PINS ref: TR010054

M54 to M6 Link Road Scheme – Response to Section 51 Advice Letter Dated 28th February 2020 and Application Errata

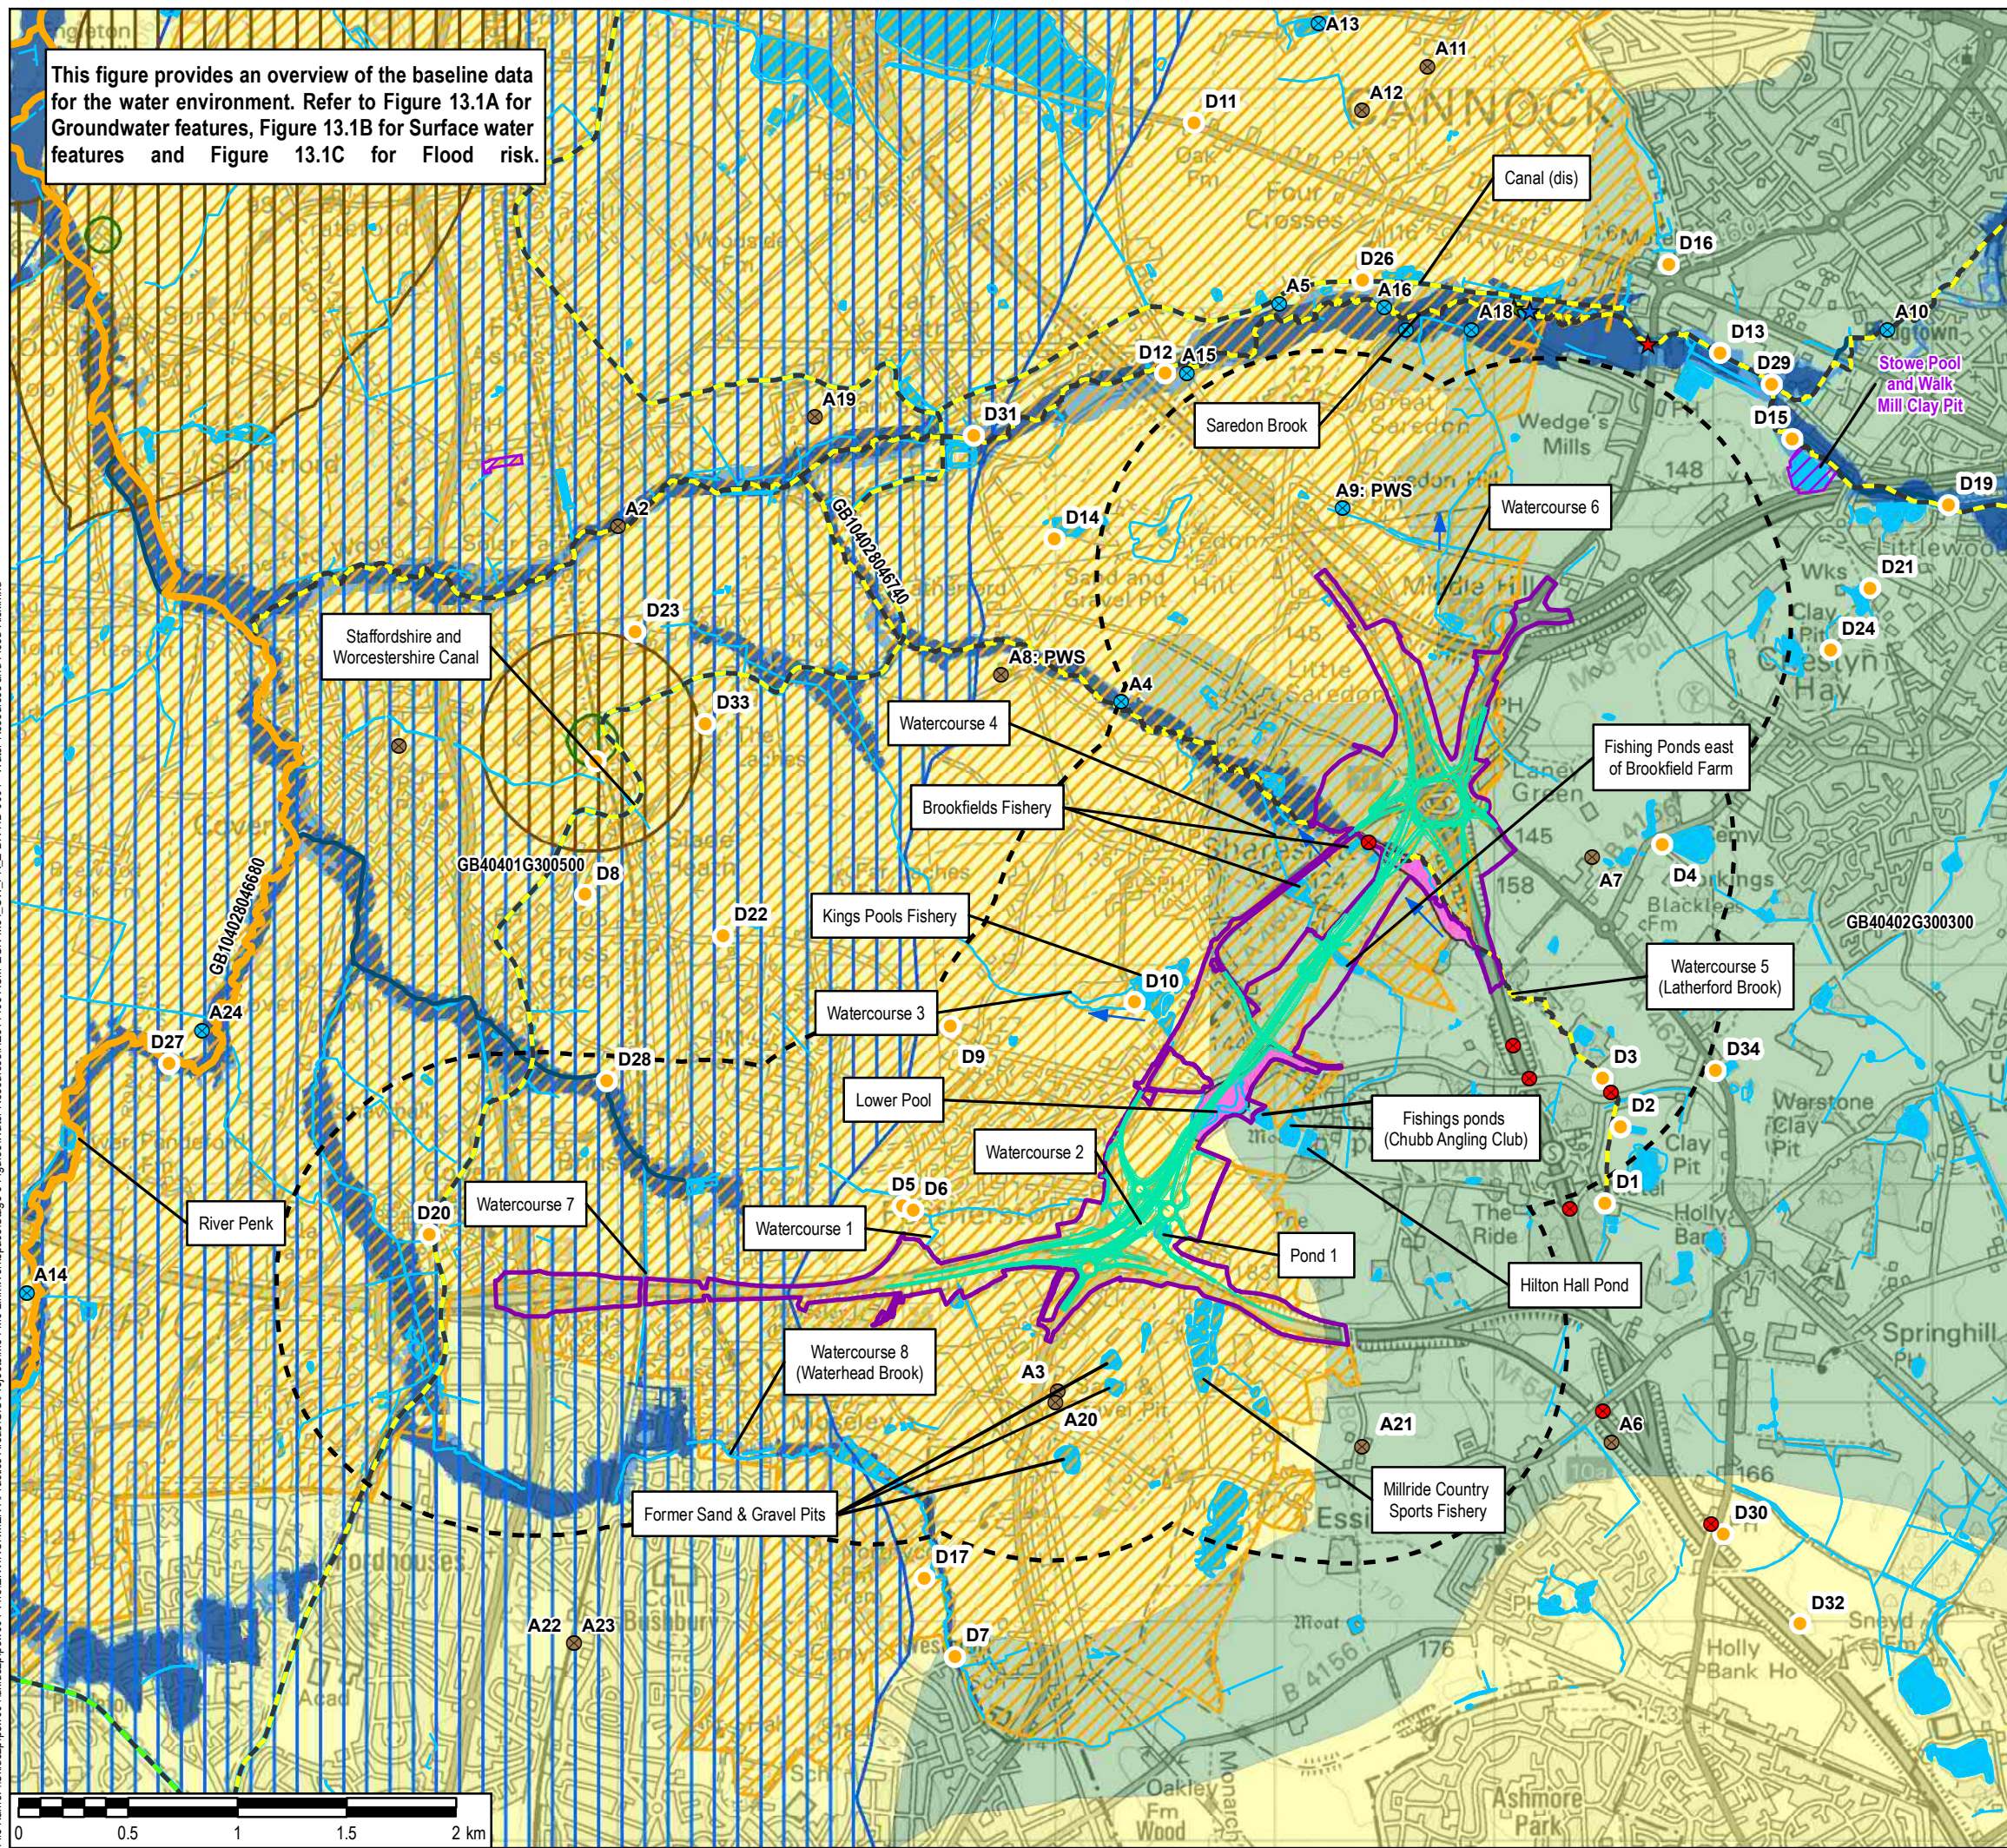
Multiple data layers have been presented in Figure 13.1 'water bodies and their attributes'. We would request that the Applicant re-submit Figure 13.1 in a clearer format; preferably with data layers presented across more than one figure no later than 10 days before the Preliminary Meeting.

In respect of Figure 13.1 'water bodies and their attributes', the figure has been split into three separate figures for clarity. Given that there are reasons consultees may want to be able to look at all attributes on one plan, the original combined plan has also been retained so that the figures in 13.1 now comprise:

- Figure 13.1 – 'Water bodies and their attributes'
- Figure 13.1A – 'Water bodies and their attributes groundwater resources'
- Figure 13.1B – 'Water bodies and their attributes surface water resources'
- Figure 13.1C – 'Water bodies and their attributes flood risk'
